Re: St. Margaret's Recycling & Transfer Centre Ltd, Sandyhills Planning Reference SU06F.321465

I refer to the planning application ABP No: 321465 which were submitted by Saint Margaret's Recycling & Transfer Centre Limited, and I have a number of observations to make on the matter.

Figure 3.4 Unauthorised Development

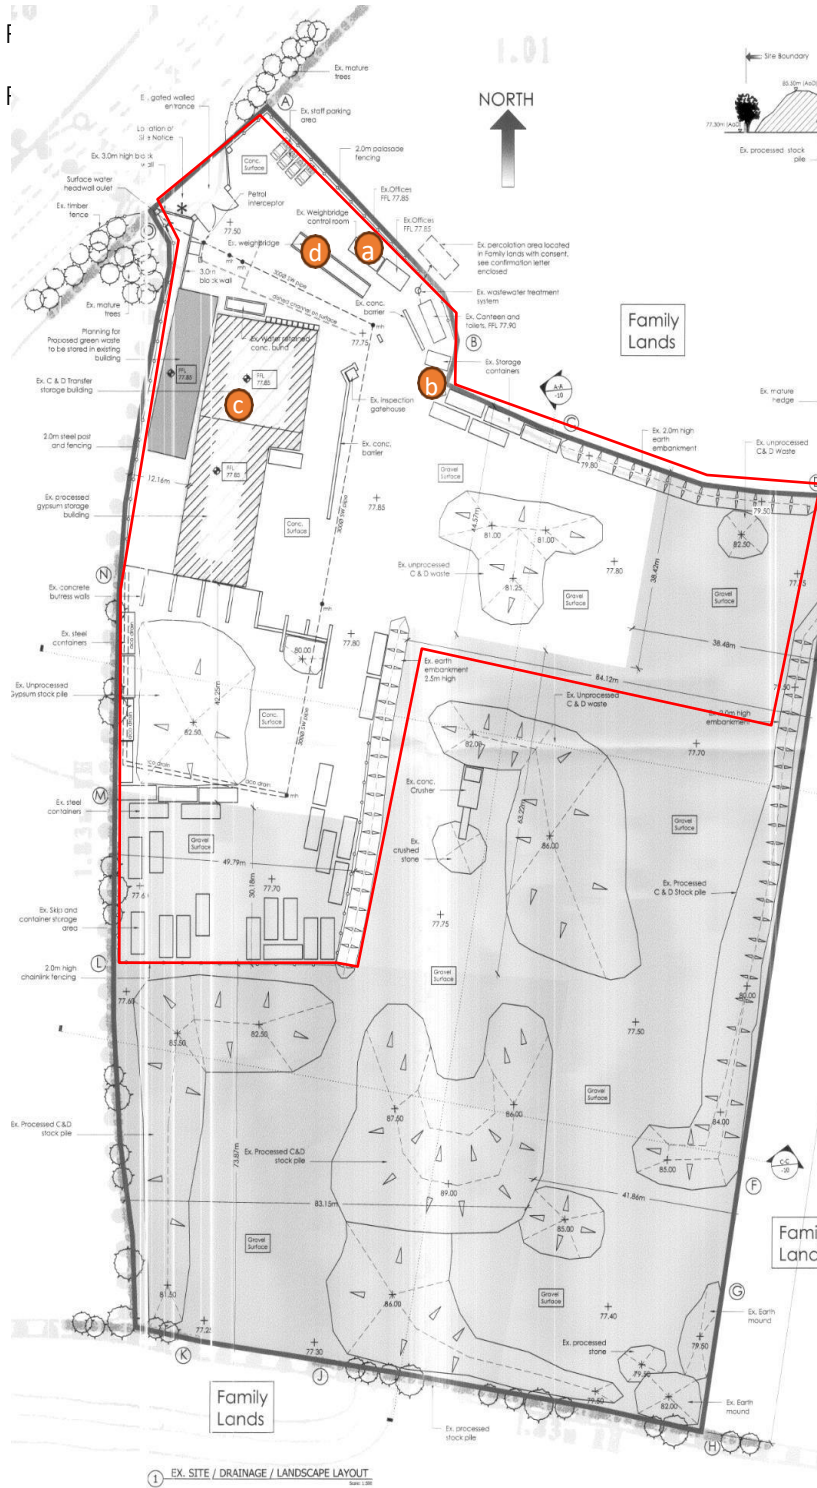
In figure 3.4 Unauthorised development.

The information provides us refers to machinery comprising of hammermill, shredders and balers on site since 1995 in the position noted on the drawing. This is not correct please see attached Google Maps satellite photographs: **Exhibit 2**

The tilters alluded to on figure 3.4 were introduced post 2013 for turning containers (40 foot) for loading scrape, so we're not on site in 1995. The information provided in this section is false.

In Figure 3.4 CWPA planning report, on behalf of the applicant advises that

*"Machinery comprising hammermill, shredders, bailers, et al (understood to be exempt development/on site since 1995, never explicitly referenced in development descriptions."*

yet in a Waste Facility Application to Fingal County Council in December 2009, there are a number of basic items of plant listed as being used/required for the site activities but there is NO mention of hammermills, bailers or tilters or forklifts of being on site See **EXHIBIT 15**
